**muswellbrook
shire council**

28 July 2020

**Bayswater Power Station Water and Other Associated Operational Works Project –
SSD 9697 – Muswellbrook Shire Council Comment**

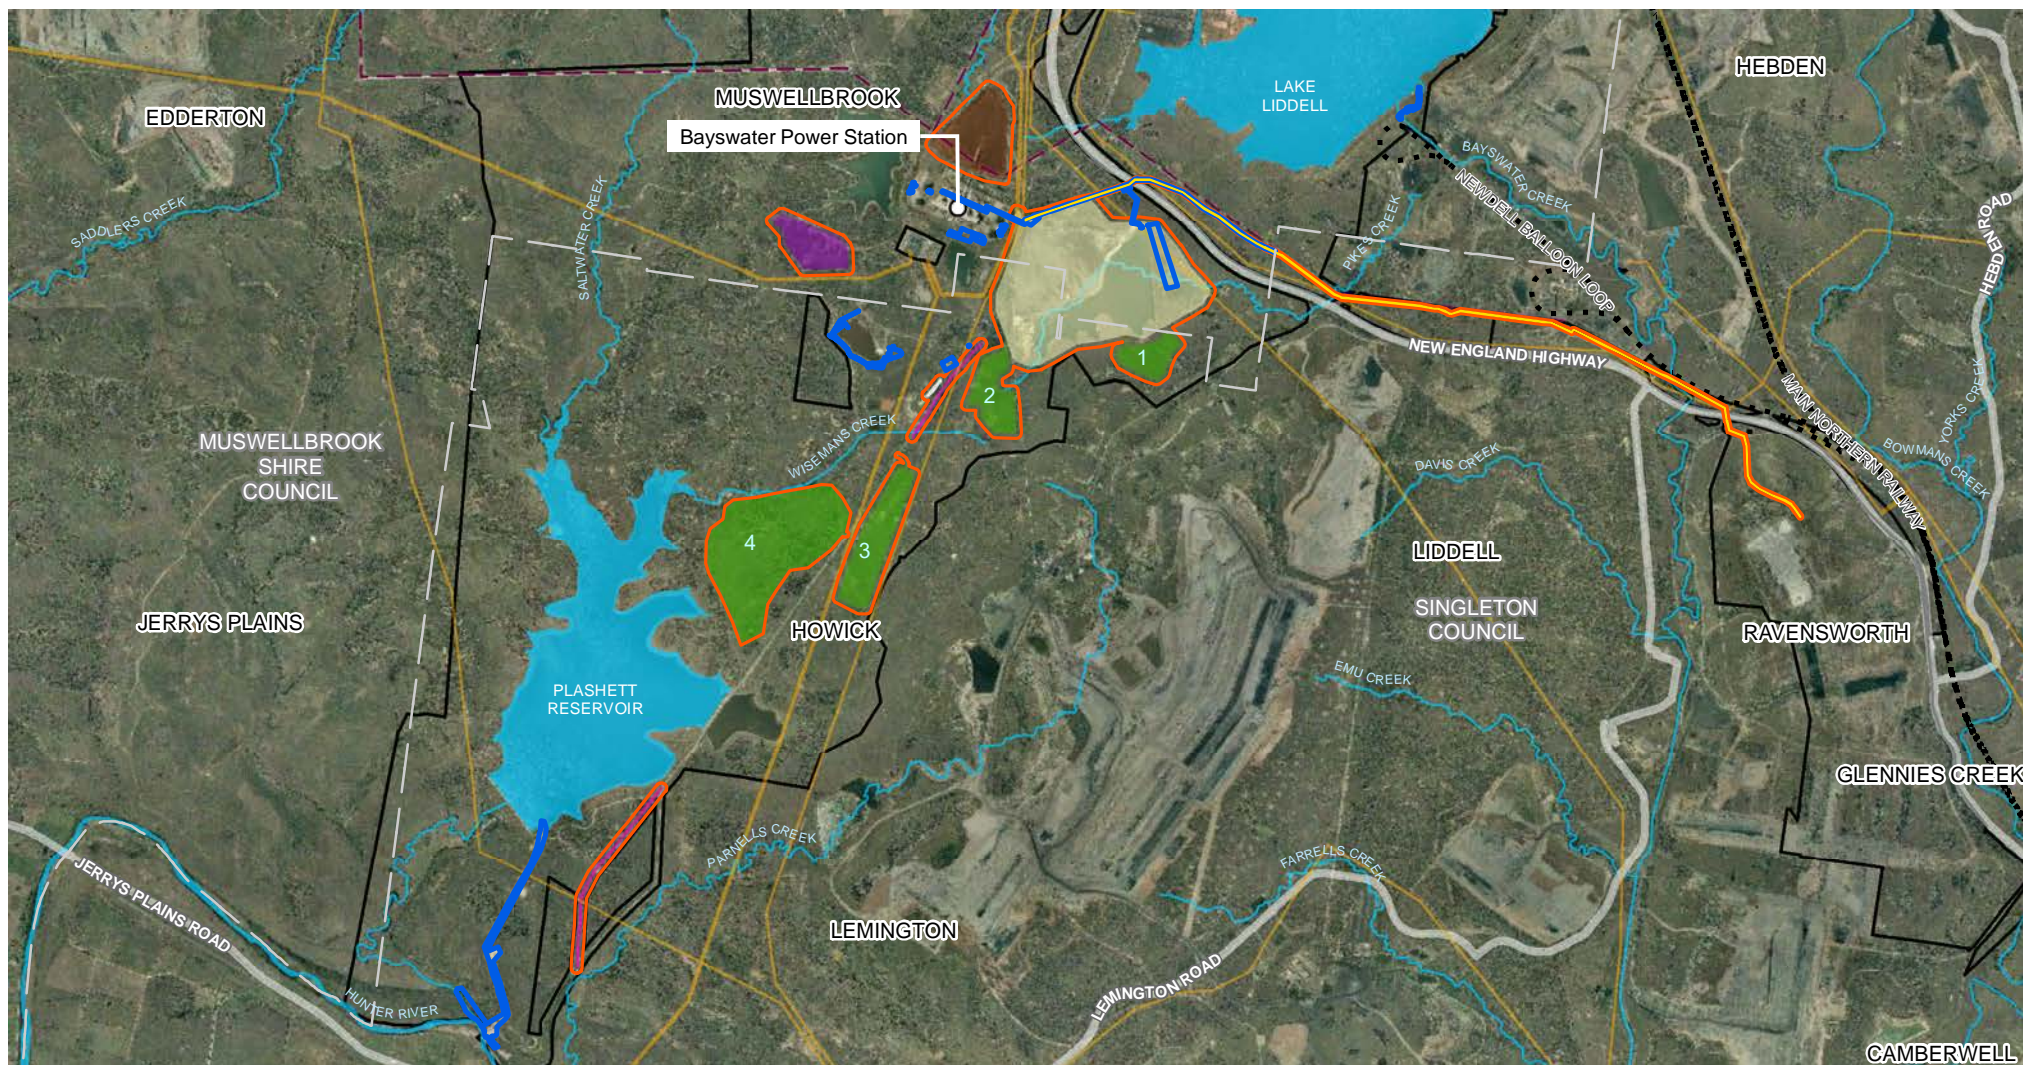
- 4.4 The EIS states that the height of the BWAD wall will be increased by 11.5 metres and will be the most visually prominent element of the Project. Unfortunately, there is only a simple sketch providing one cross-section, on page 59 of the EIS, that can be used to gauge the extent of proposed works. From that sketch it is not clear how much alteration to the existing wall is proposed. To increase the wall height by 11.5m would normally require an increase in the width of the wall as well.

Figure 4.14: Salt cake landfill conceptual hydrogeological cross section

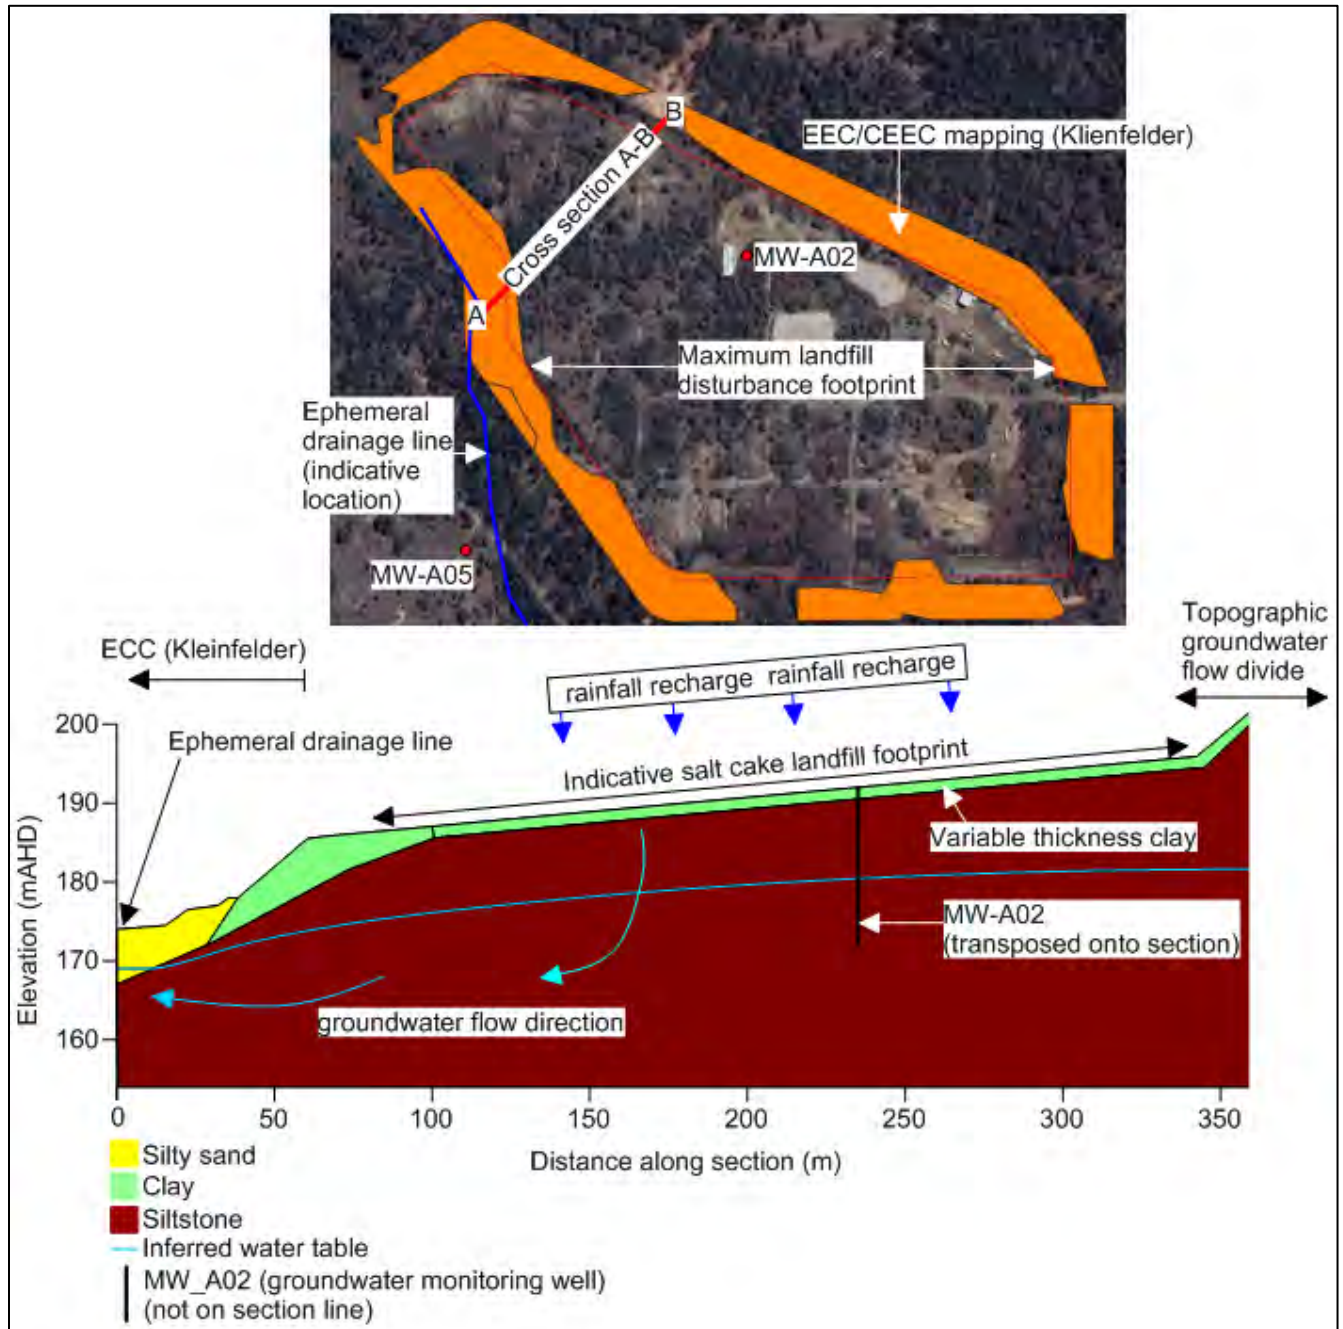
- 6.1 The Surface Water, Groundwater and Flooding Technical Paper (Appendix D of the EIS) discusses possible issues that may arise if the leachate liner for the salt cake landfill leaks, there is higher than expected levels of seepage from the Ash dam or the ash pipelines break etc. There is regular low-level seismic activity (generally measuring less than 4 on the Richter scale) in the Muswellbrook LGA with epicentres predominantly near Mt Arthur mine, which is close to Bayswater Power Station. On

average there are two events/month. All liners and structures should be designed to withstand this regular seismic activity, and an inspection regime must be in place for infrastructure following notification by Geosciences Australia that a seismic event has been recorded in the Muswellbrook LGA or the northern half of the Singleton LGA.
